Subject: Application WA/93/20/PL - Tye Lane, Walberton, BN18 0LU - Alternative access & emergency access along with minor highway works following WA/95/18/RES. This site is in CIL Zone 2 (Zero Rated) as other development.

Site: Tye Lane, Walberton, BN18 0LU

Your Reference: WA/93/20/PL

Highways England's Reference: 89941 #12039

Appendix B
Traffic Flow Diagrams

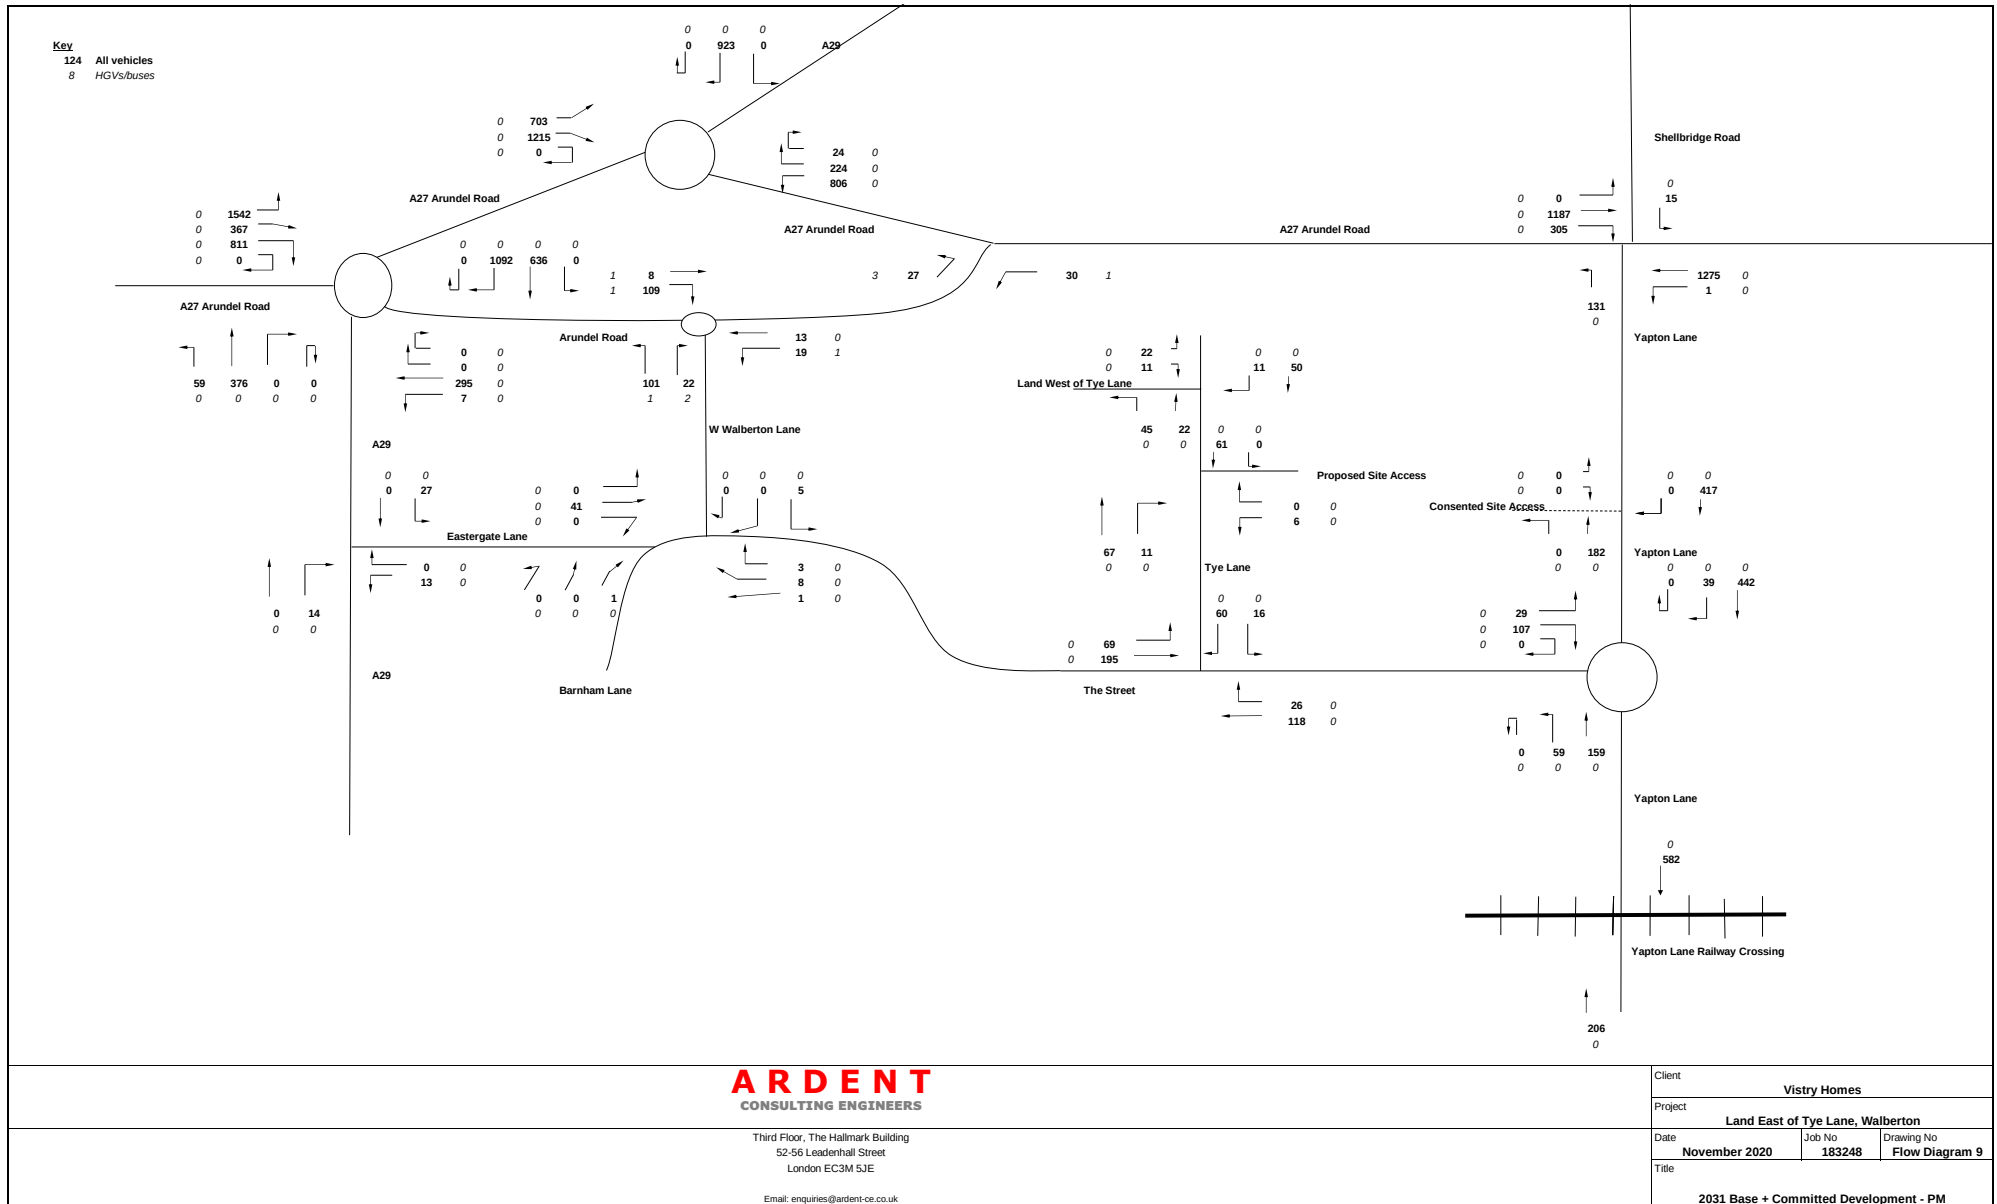
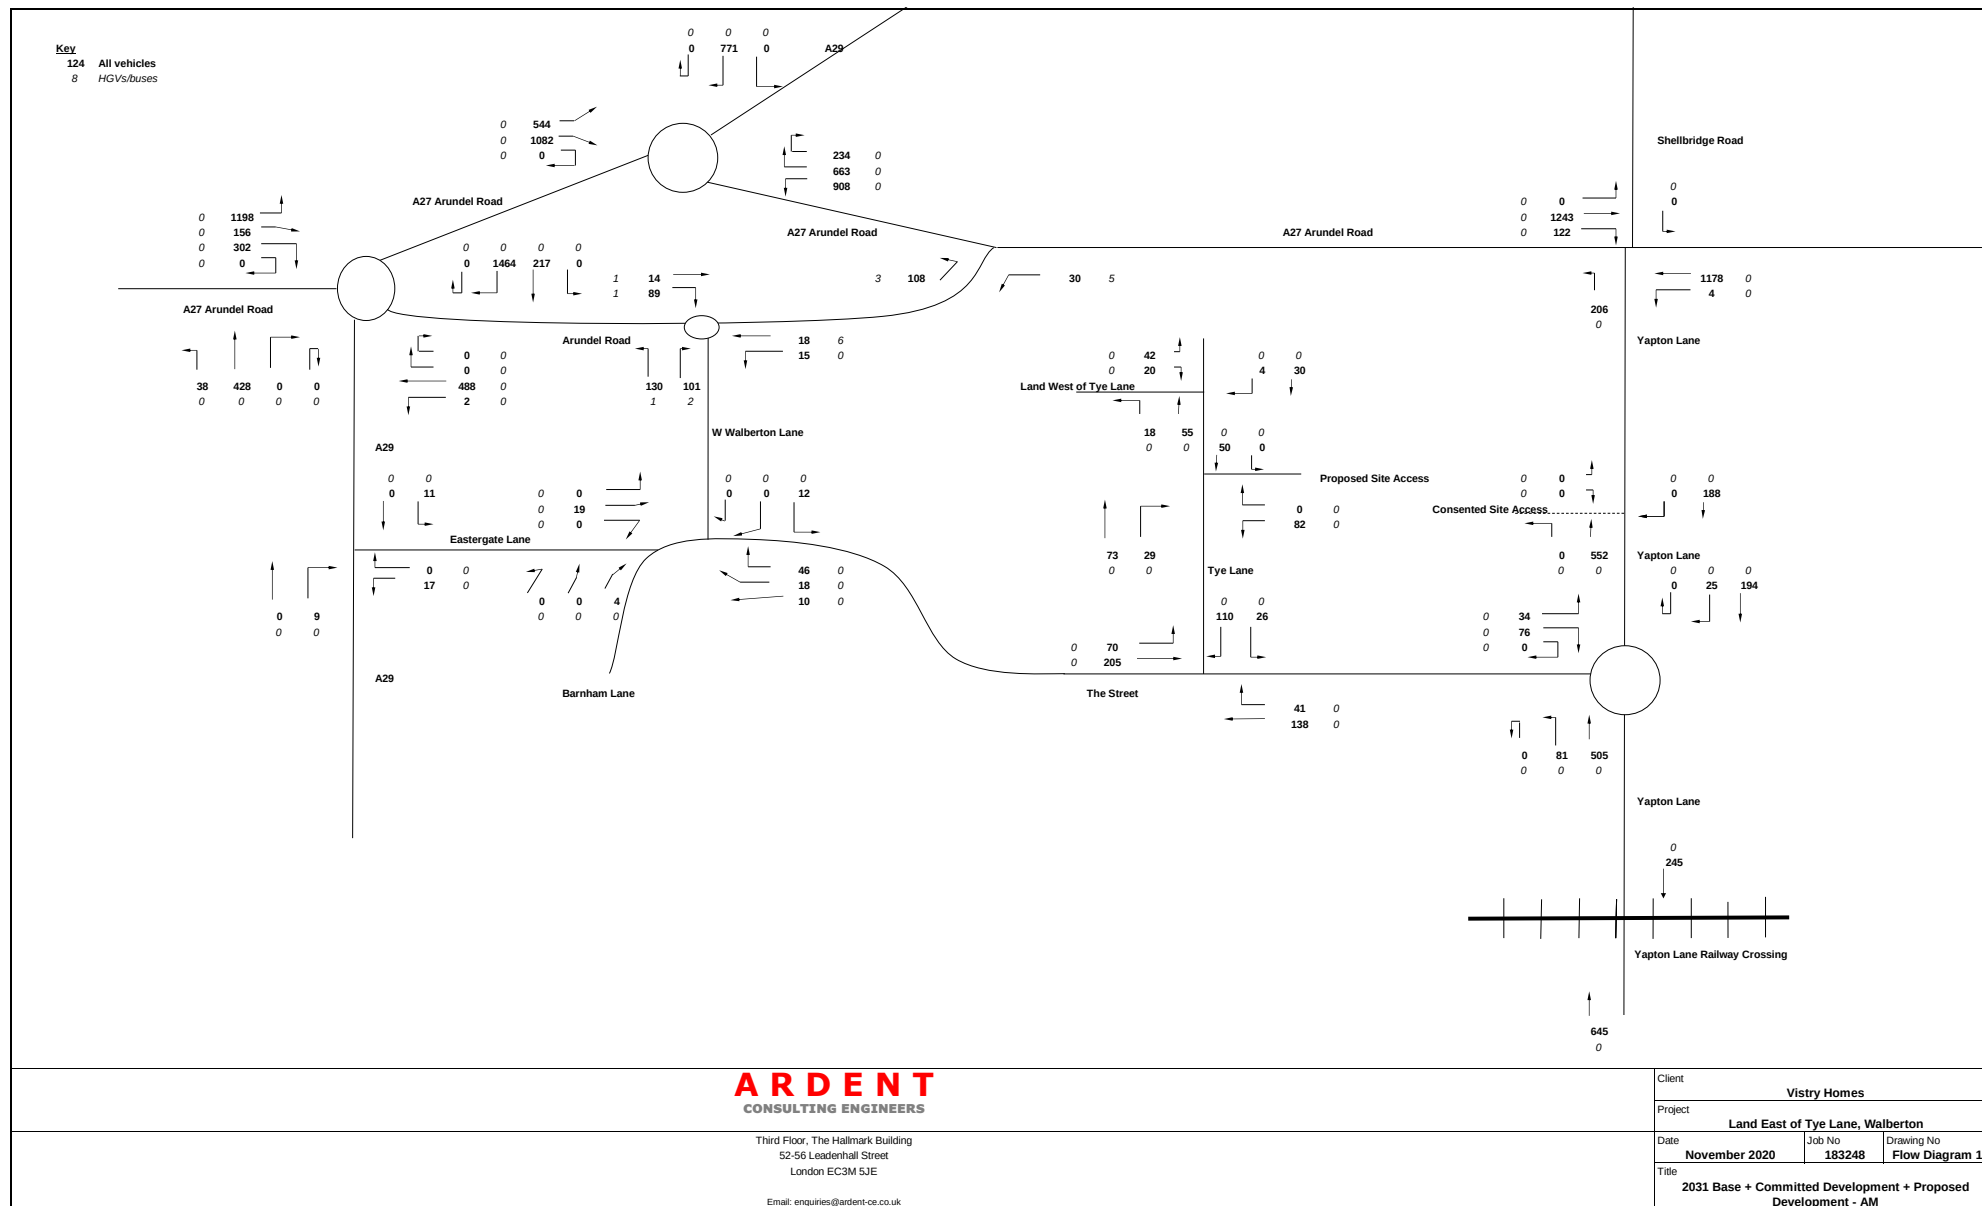
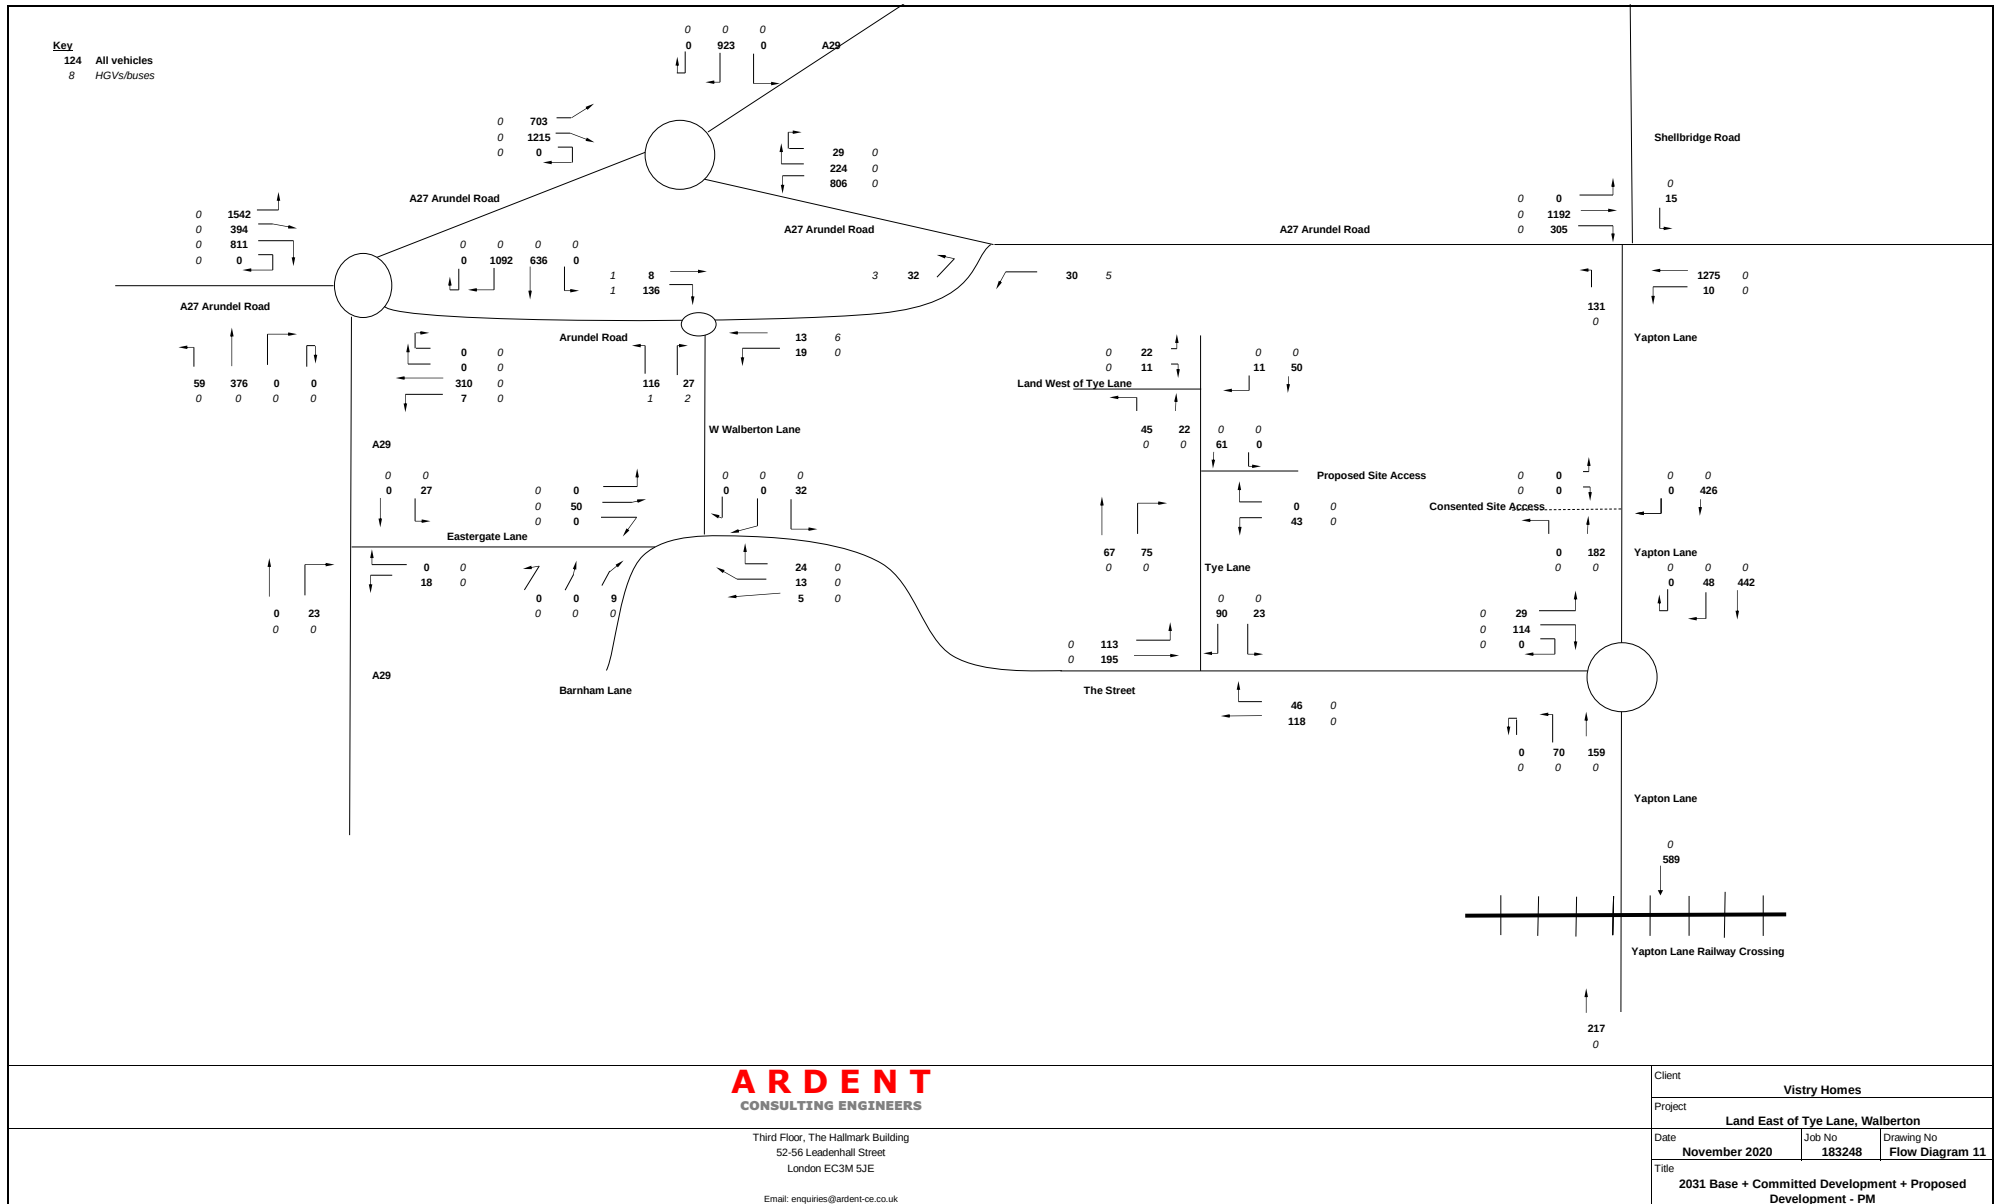
- Paragraph 1.4 outlines that this application has been submitted as a result of Highways England's preferred route Announcement for the A27 Arundel Bypass scheme, yet:
 - Paragraph 5.1 outlines that the 2031 future year scenario from the consented scheme has been used to consider background traffic. However, this did not consider the A27 Arundel Bypass. As such, all scenarios should be revised to reflect the A27 Arundel Bypass. In this respect, we recommend that the applicant contacts the A27 Arundel Bypass team for further information:
[REDACTED]
 - The traffic flow diagrams do not appear to reflect this (e.g. Yapton Lane still appears to be connected to the A27). Therefore, please can this be clarified/the traffic flow diagrams be updated accordingly?
- In addition, please can a traffic flow diagram be provided to show the proposed development flows on their own?
